Appeal NO: ABP 314485

Bord Pleanála Case Number: ABP-314485-22

Planning Authority Case Reference: F20A/0668

Observations relating to Bord Pleanála Case reference ABP-314485-22 subsequent to the receipt of additional information from daa.

Figure 1 The present EIAR claims the coloured area as the "permitted" scenario.

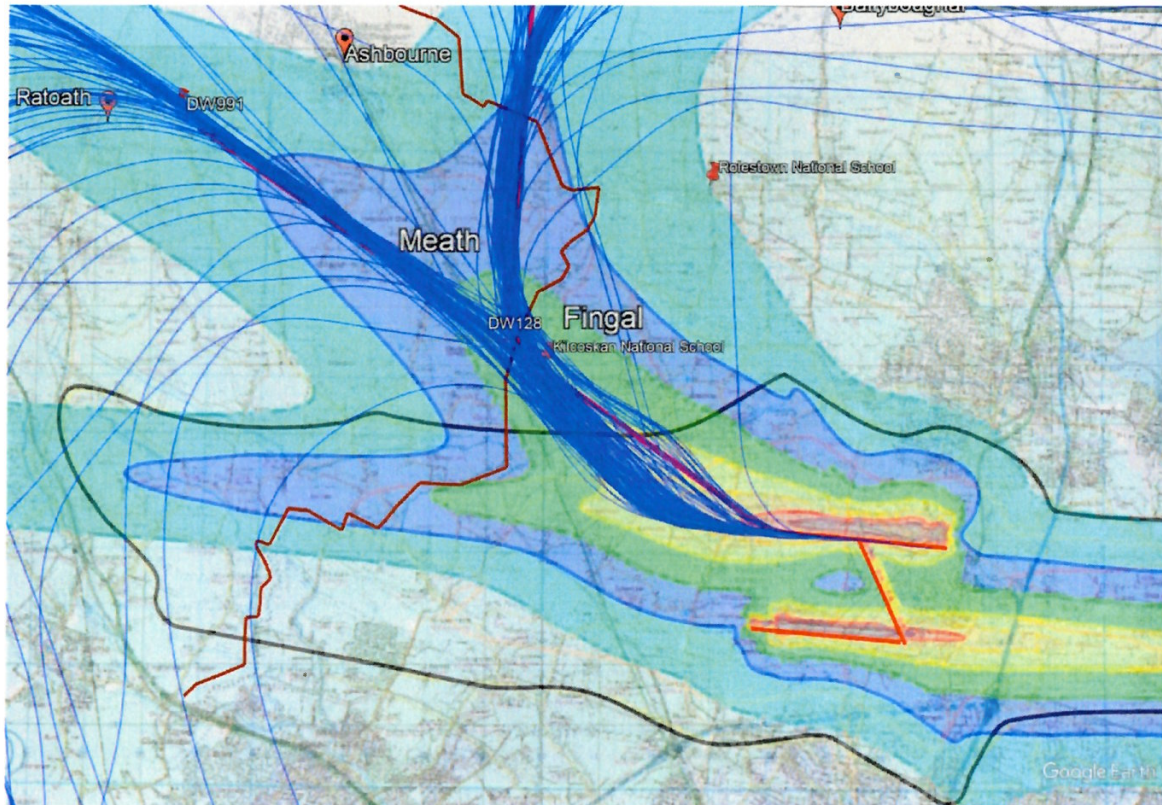
In Figure 1, daa's Forecast Lday Noise Contours 2035 Permitted Scenario Figure 13C-23 are overlaid with the current traffic. The magenta tracks currently in use form the 4th flight-path design so far by daa/AirNav and only went into operation in February of 2023.

Examination of the original EIS (shown with a black outline) demonstrates that the Noise Contours in Figure 1 are nowhere near the noise contours claimed as permitted in the current EIAR. Simple logic dictates that it is impossible that these noise contours are the "Permitted Scenario".

Figure 2 New submission from daa further clarifying breach of Condition 1 of the granted permission

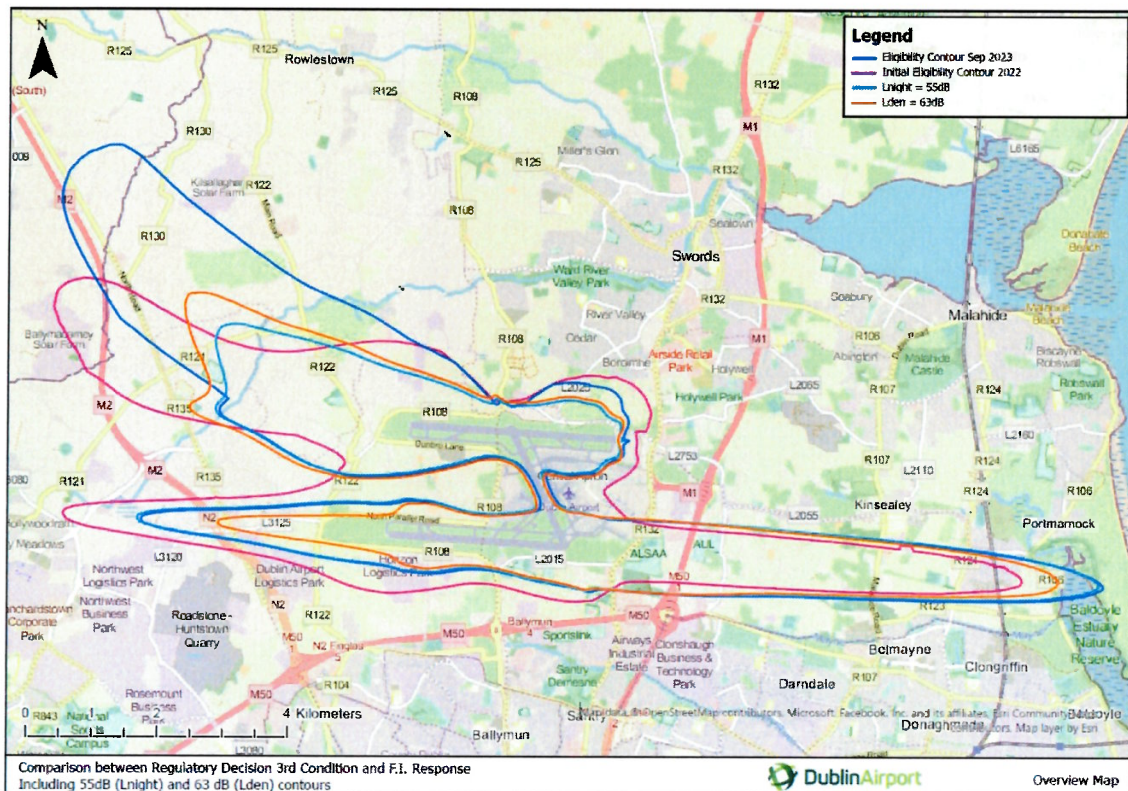
Figure 2 supplied by daa shows that the RWY28R SID is in clear breach of Condition 1 of the granted permission.

Figure 3 Latest ANCA data demonstrating noise all the way up to Ashbourne and Ratoath

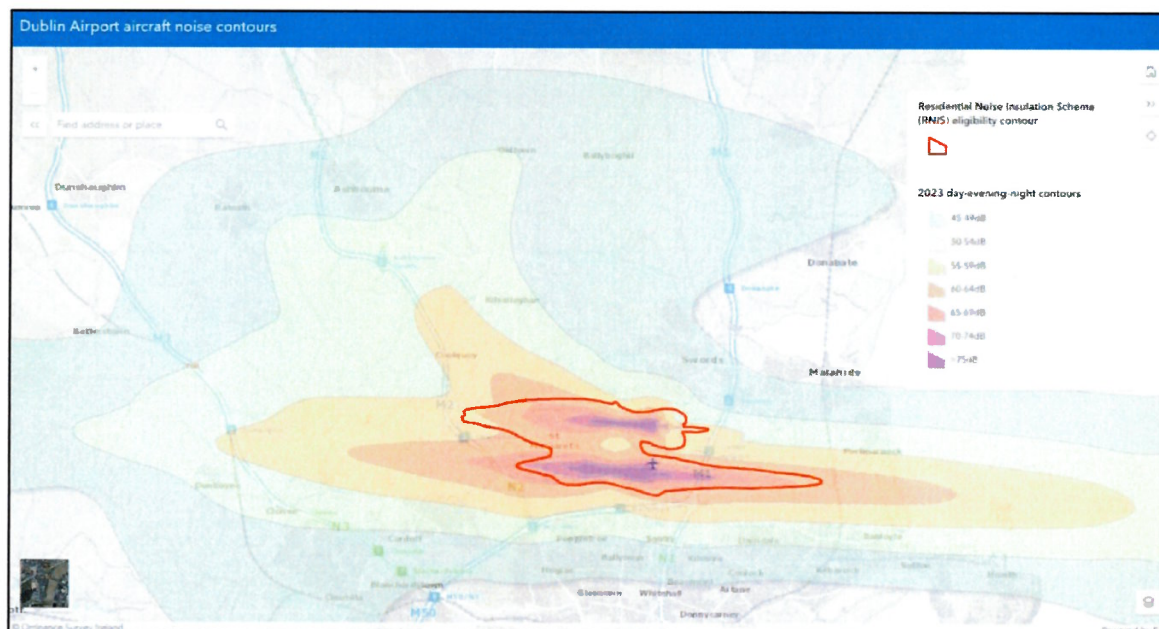
Once again, daa's new submission demonstrates their casual disregard for condition 1 of the only planning permission in force for the north runway.

This Chart shows the outline of the 2007 planning permission, with green lines indicating the intended flight paths, and the red the actual flown illegal flight paths.

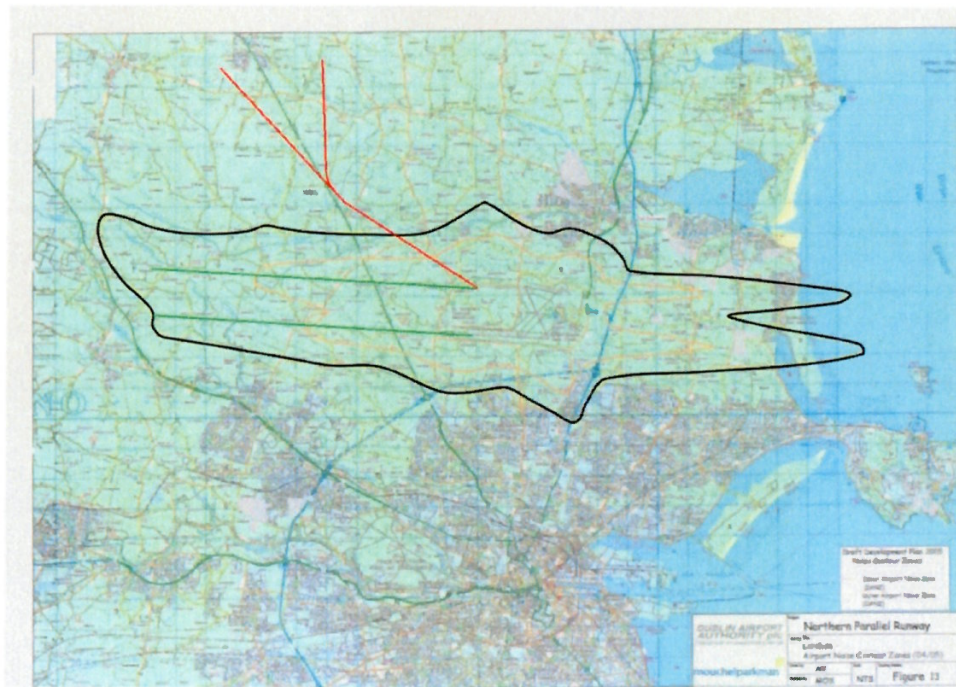
This Chart shows the outline of the 2007 planning permission, with green lines indicating the intended flight paths, and the red the actual flown illegal flight paths.

This chart shows the Public safety zones as part of the 2007 planning permission. In red the actual illegal flight paths.

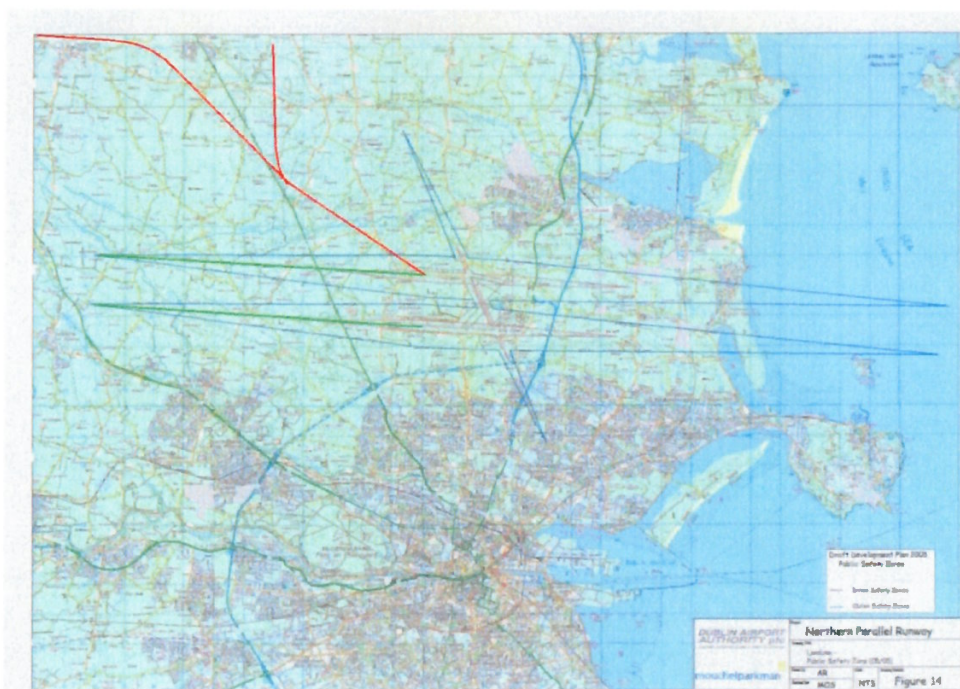
This chart shows the Public safety zones as part of the 2007 planning permission. In red the actual illegal flight paths.

Here is a 16 hour period of flight paths, with the Black outline showing the only approved planning permission EIS, with the green proposed flight path used for that planning application.

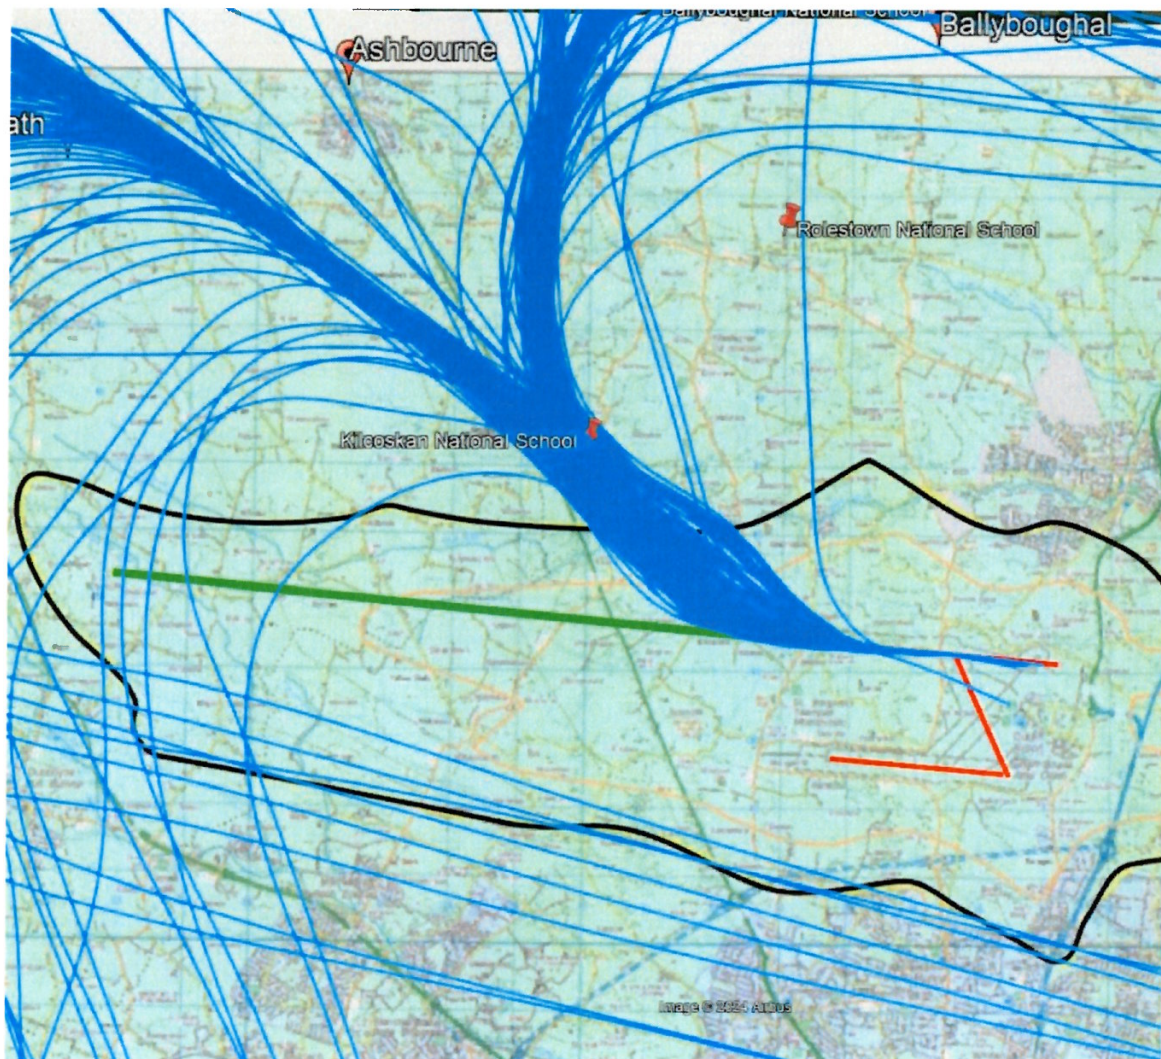
Here is a 16 hour period of flight paths, with the Black outline showing the only approved planning permission EIS, with the green proposed flight path used for that planning application.

Because the aircraft have to make so many turns their ability to climb is reduced significantly, and therefore the noise impacts of departure tracks with large turns compared to straight departures is compounded, with aircraft flying lower for longer periods creating more noise.
